MMO Reference: DCO/2016/00005  
Planning Inspectorate Reference: EN010078  
Interested Party Identification Number: 20024119

24 January 2020

**Planning Act 2008, Scottish Power Renewables Limited Proposed East Anglia Two Offshore Windfarm Order**

**Relevant Representation**

East Anglia TWO Mackerel Spawning and Nursery Grounds in Relation to Worst Case Noise Impact Contour (Fleeing Model)		Drg No	EA2-DEV-DRG-IBR-000655	
										Rev	2	Datum: WGS 1984 Projection: Zone 31N
										Date	24/06/19	
										Figure	10.42

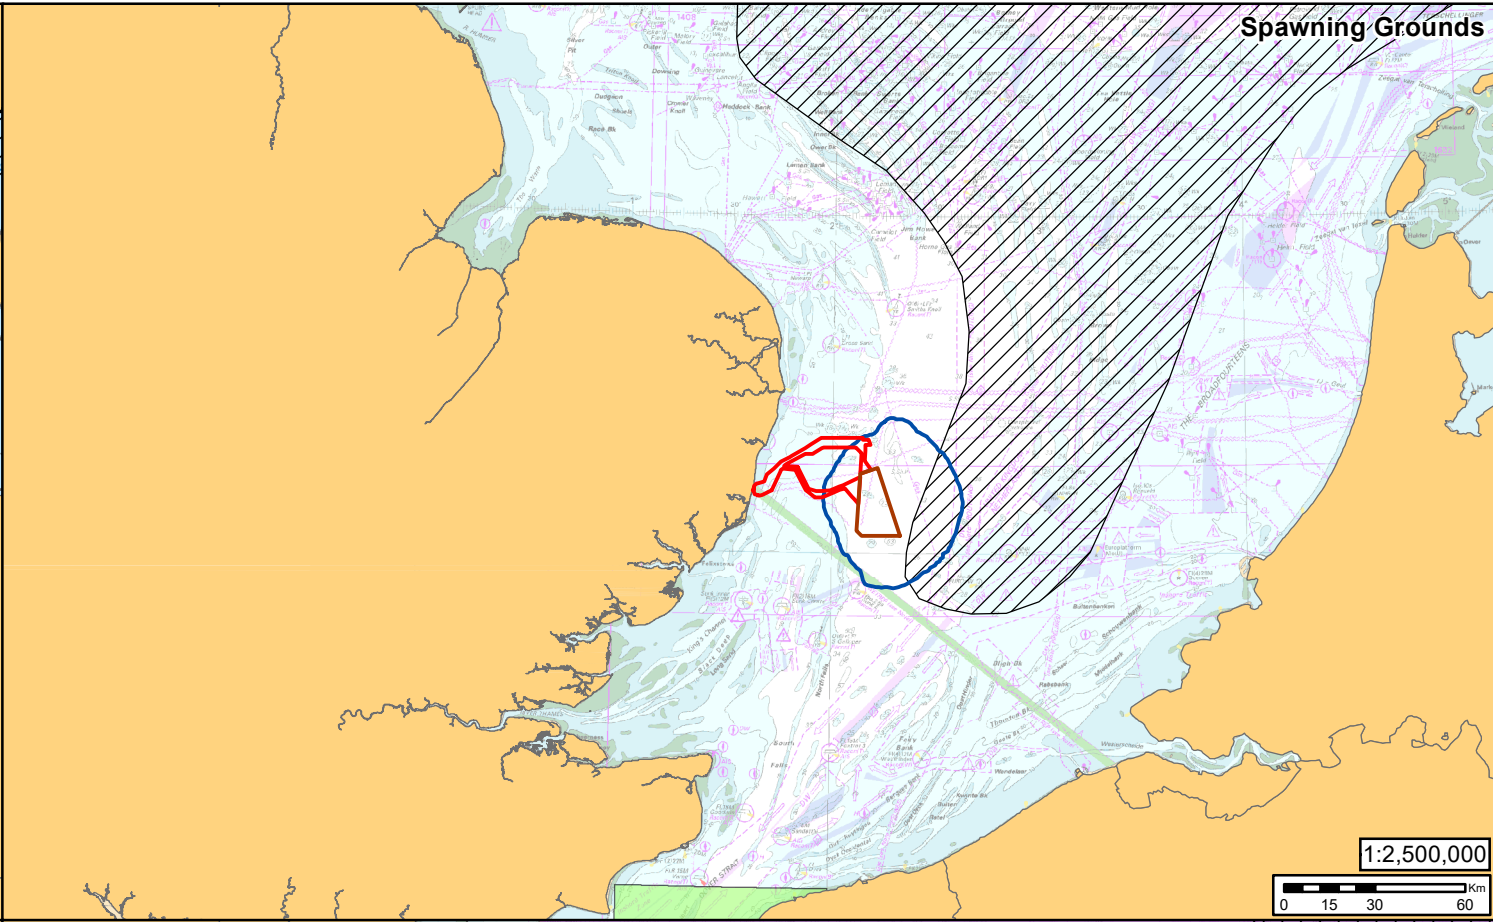
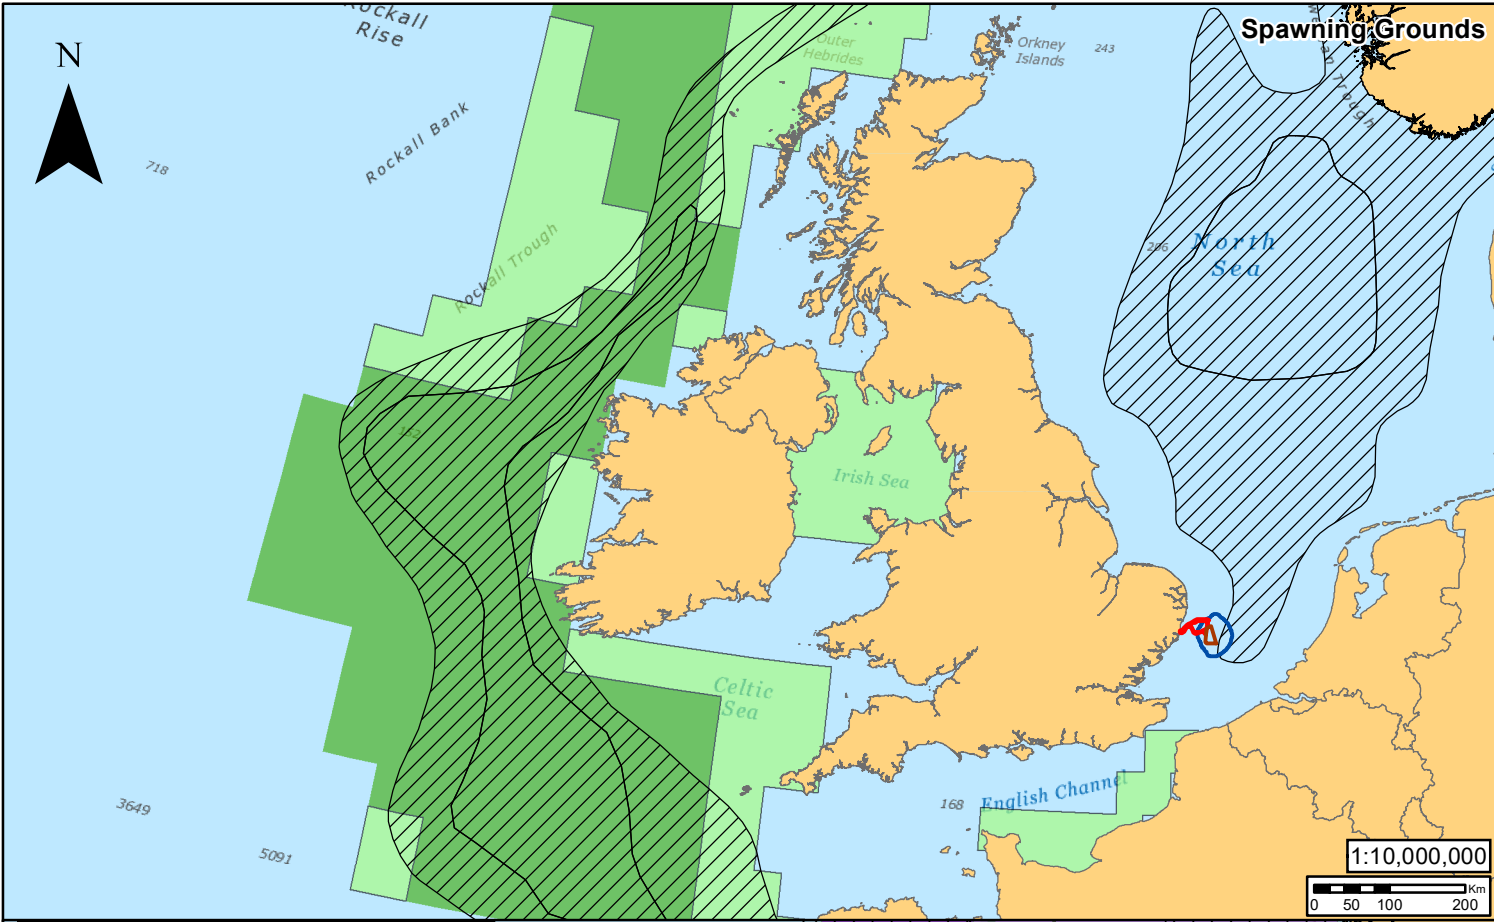
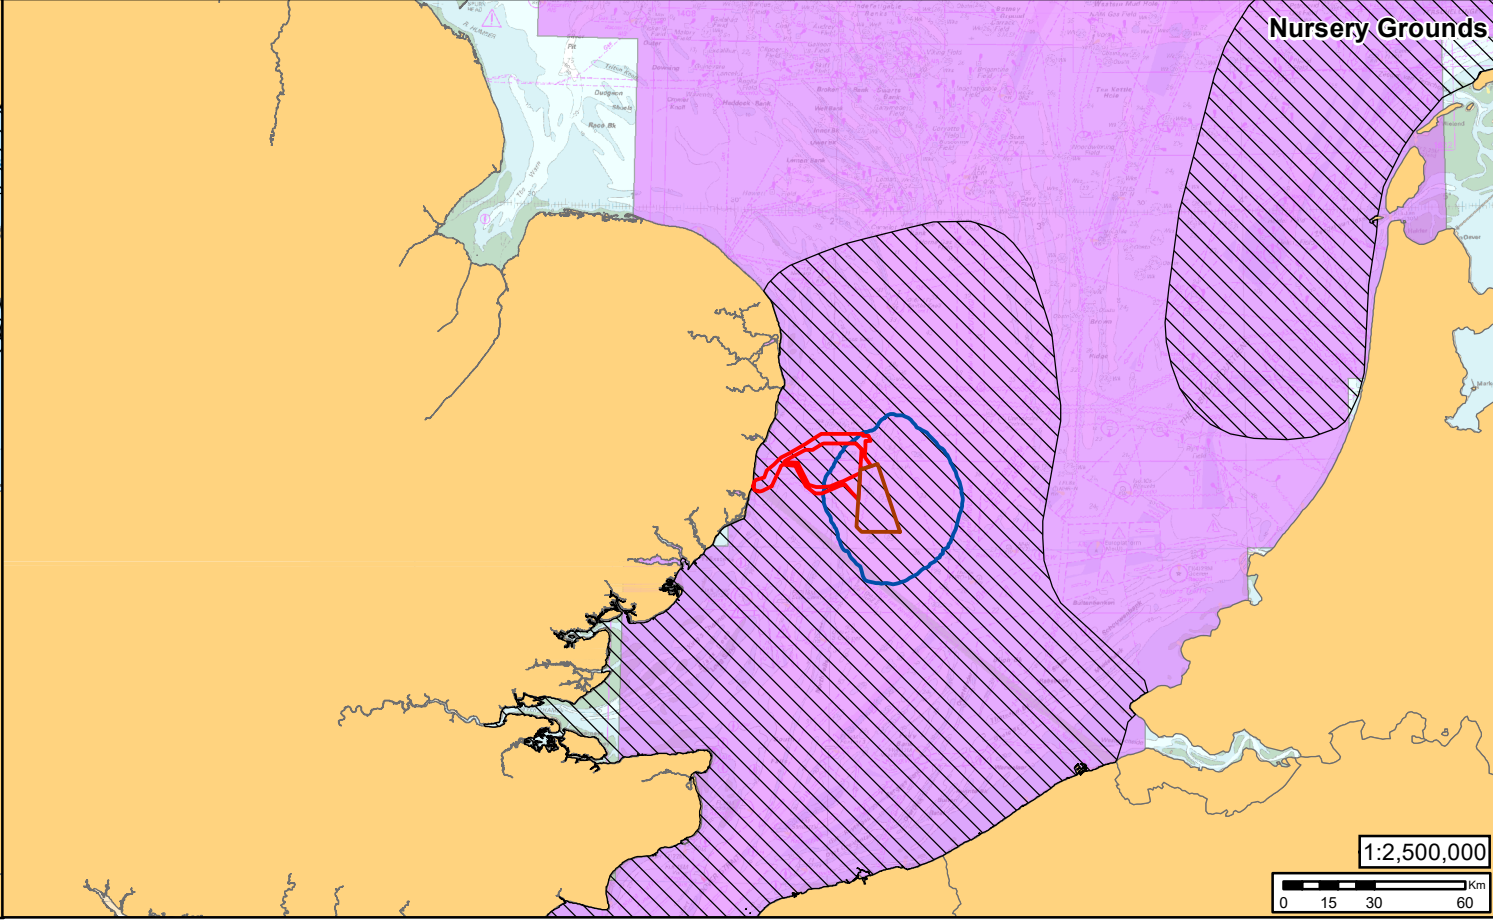
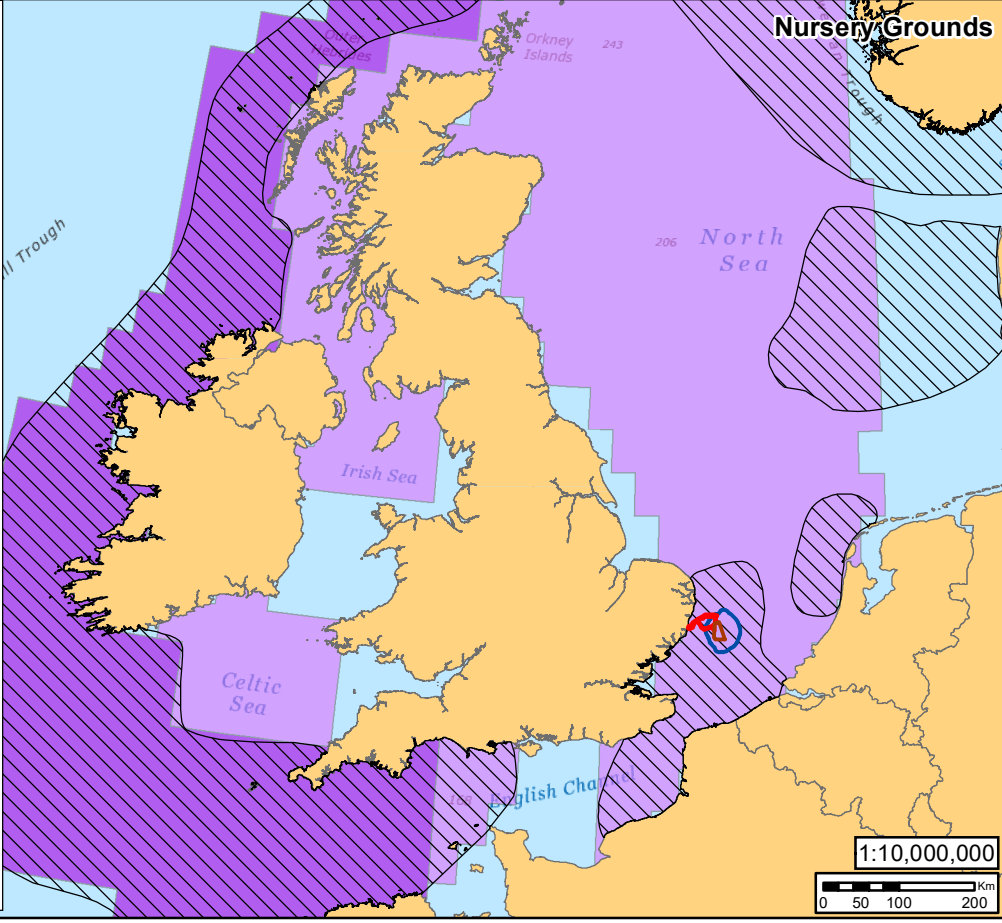
- 3.4.3 Figures 10.34 -10.45 present the Temporary Threshold Shift (TTS) noise contour for fish species that have spawning and nursery grounds overlapping, or near, to the EA2 site. The modelling used to inform these outputs is based on a fleeing receptor model and pin pile. The title on each of these figures is given as: ‘Spawning and Nursery Grounds in Relation to Worst Case Noise Impact Contour (Fleeing Model)’. The MMO does not consider this to represent the worst case scenario for the following reasons;

- 3.4.3.1.1 Use of fleeing receptor; The MMO raised major comments regarding this during the our section 42 response during the PEIR stage that we did not support the use of a fleeing receptor model for fish and provided recommendations for how best to present the modelled data for noise, using monopiling and a stationary receptor as the worst-case scenario.

- 3.4.3.1.2 The MMO notes that the applicant has used pin pile hammer energy for the modelling in figures 10.34-10.45 (pin piling using a hammer energy of 2400kJ). However, monopiles are expected to require a hammer energy of 4000kJ but the modelled noise contours for this higher energy level have not been included in the figures, therefore the applicant has not presented the MMO do not consider this to be the worst-case scenario in terms of noise propagation, especially considering the type of wind turbine and installation methods to be used at EA2 have not yet been determined.

- 3.4.4 It is acknowledged that the applicant has provided a summary of the impact ranges in Tables 5.49 to 5.60 including those based on a 4000kJ monopile and a stationary receptor. However, these have not been presented in the format requested by previous advice given at the PEIR stage and it is also recognised that an effort has been made to present the TTS noise contour over IHLS data showing larval abundance for all UK herring stocks including the Downs (Figure 10.45). However, this figure is based on a fleeing model and pin pile so again, it is not the worst-case scenario.

- 3.4.6 The MMO therefore recommended that the applicant presents revised noise modelling for a more accurate worst-case scenario based on 4000kJ monopile and a stationary receptor.
